PORTLAND MAINE

November 6, 2012

Re: 13 Carroll Street – 062 B020 – R-6 Residential Zone – Disability Variance - permit #2012-11-5324

Floor Plan  
H.C. Ramp Detail

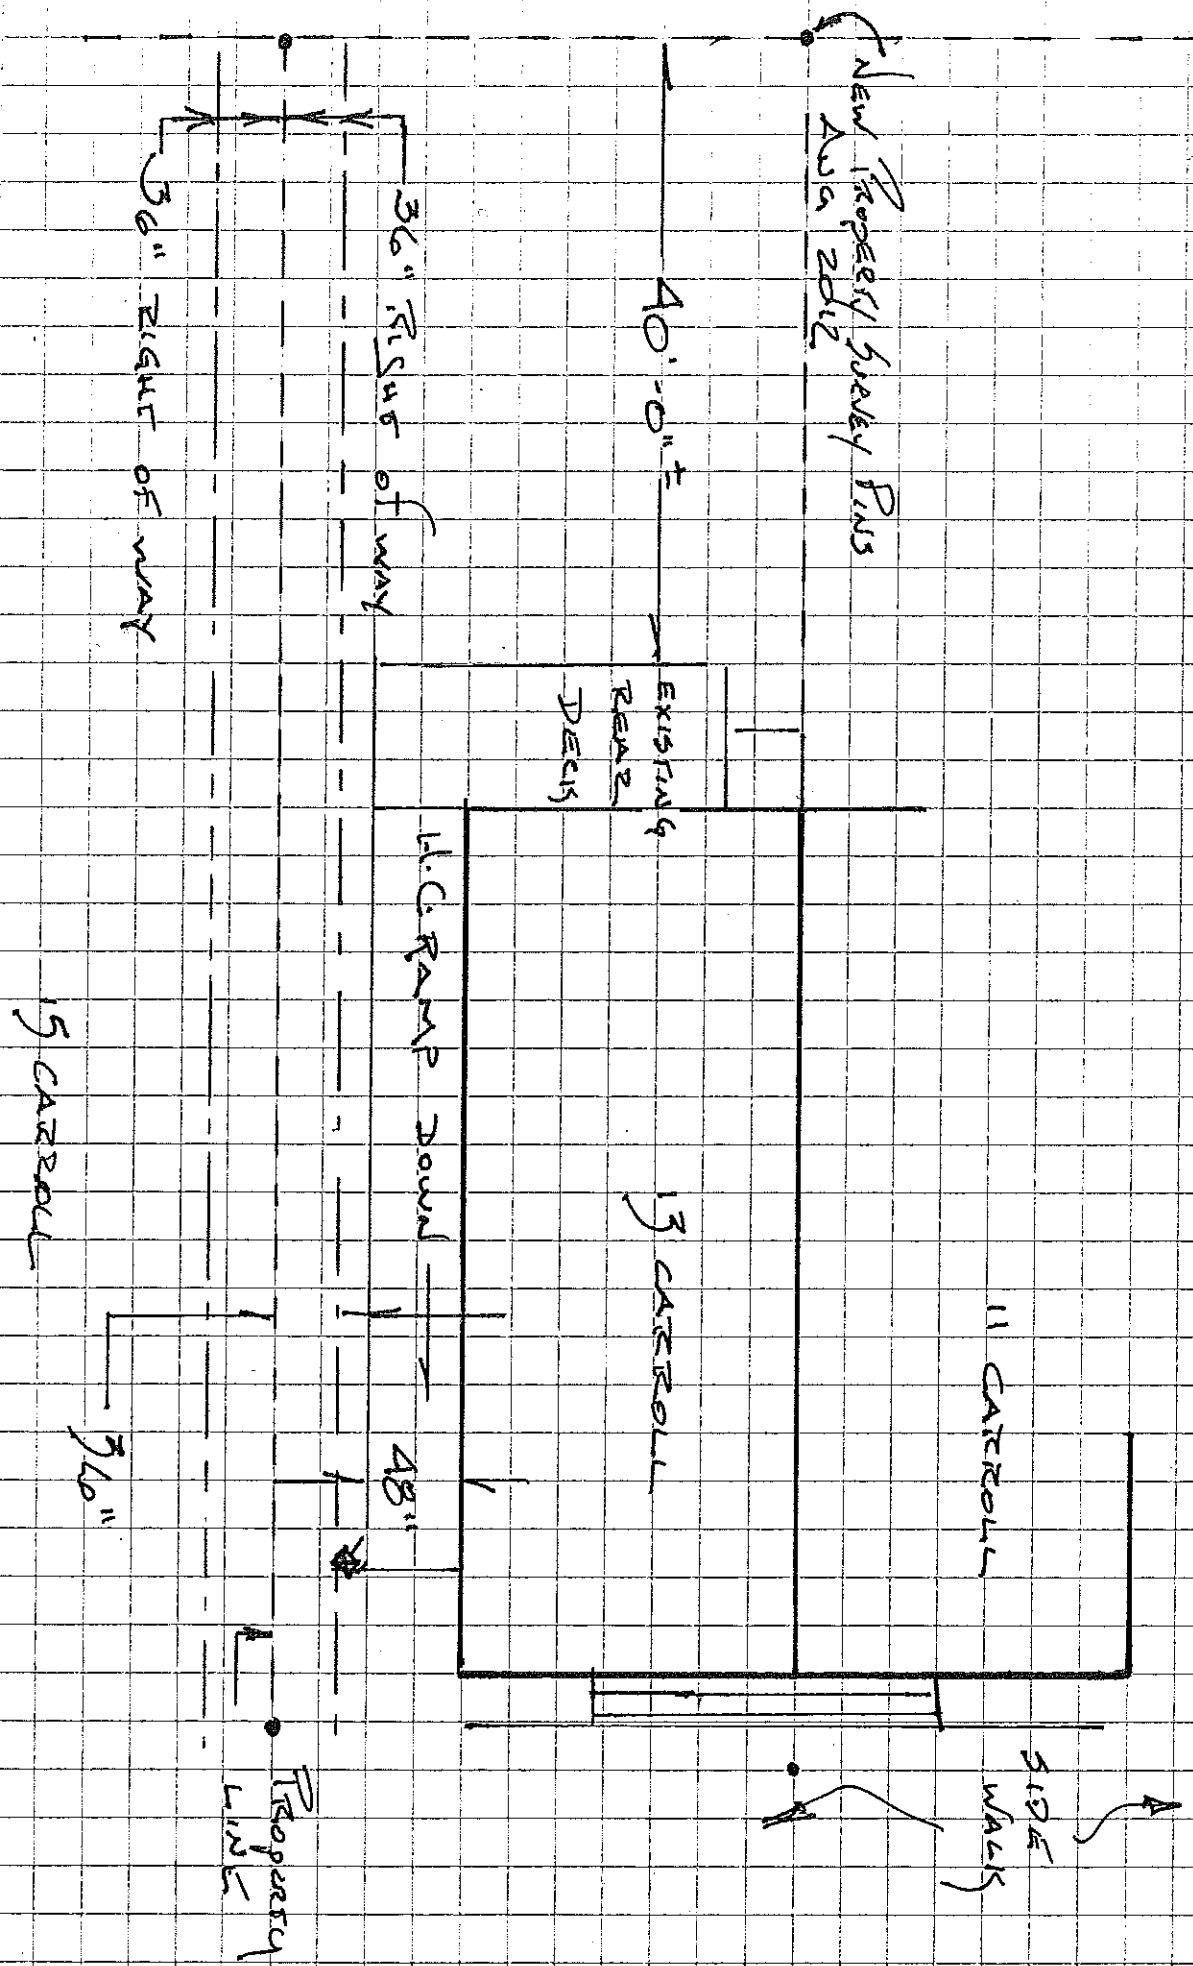
You applied for a permit to build a ramp to make your property at 13 Carroll Street handicap accessible for one of your family members. This property is located in the R-6 residential zone. The required side yard setback is ten (10) feet [section 14-139(a)(4)(c)]. The plot plan submitted November 2, 2012 gives the side yard setback from the ramp as 4' 10". Since the proposed ramp does not meet the side setback requirement, you will need to apply for a Disability Variance. Since the ramp has to be installed immediately, I am signing off on the ramp for Zoning and moving the permit forward in the review process to Historic Preservation. You will need to apply for a Disability Variance within thirty days of the permit being issued.
